V2_Traffic Impact Study_comments.pdf Markup Summary

TRAFFIC IMPACT STUDY

ELK VIEW ESTATES

PCD File no. SF266

ALIGN - PRIVATE RD 02 (STA: 0+75 TO 4+50) - SCALE: H: 1"=30' V: 1"=6'

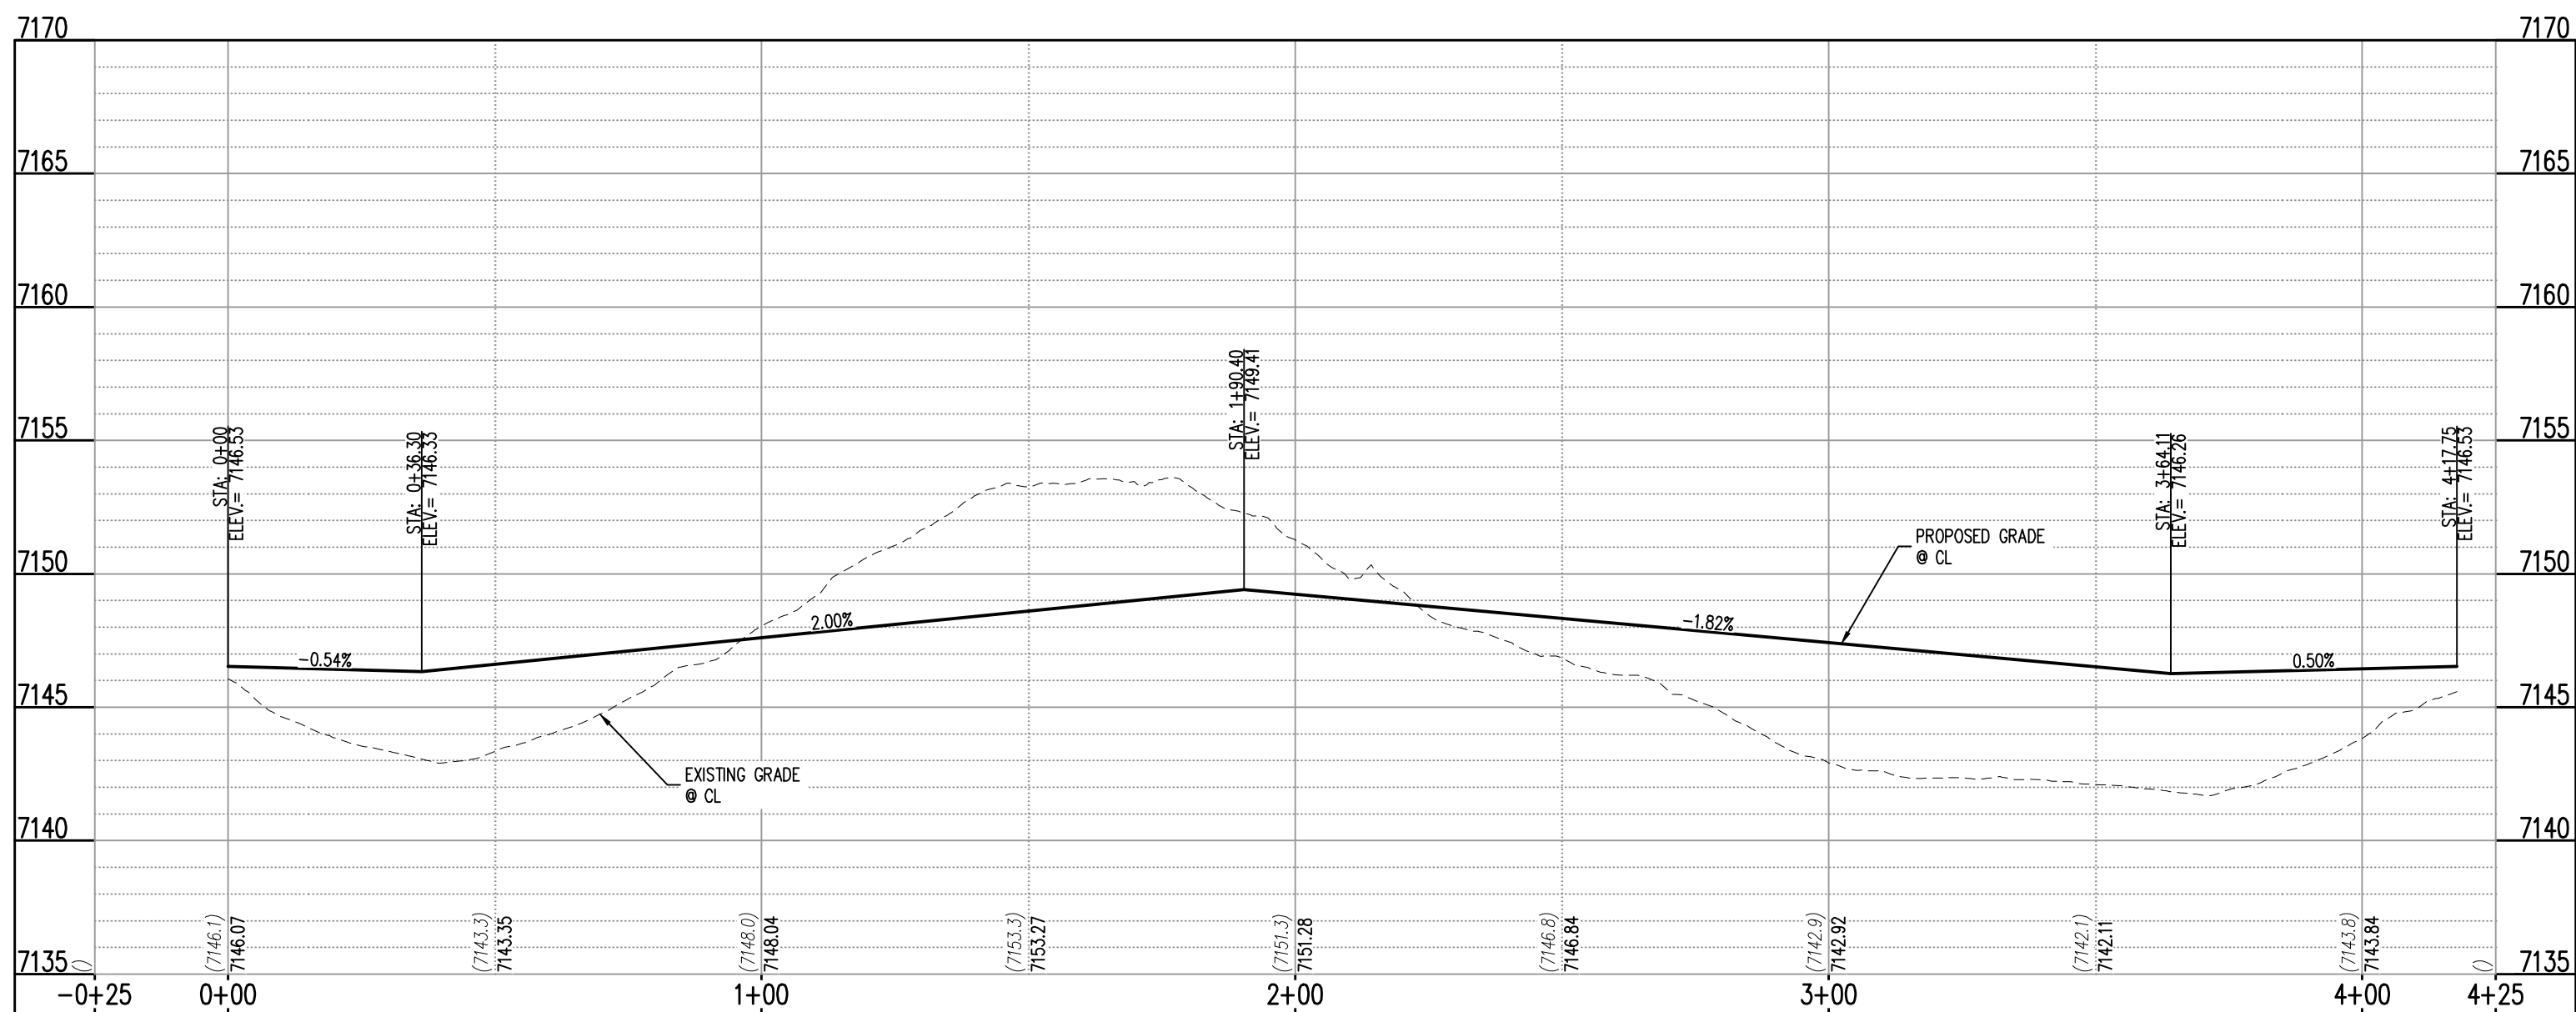
Unresolved:
Did not see site distance triangles in Appendix A.
Please provide

Unresolved:
Did not see site distance
triangles in Appendix A. Please
provide
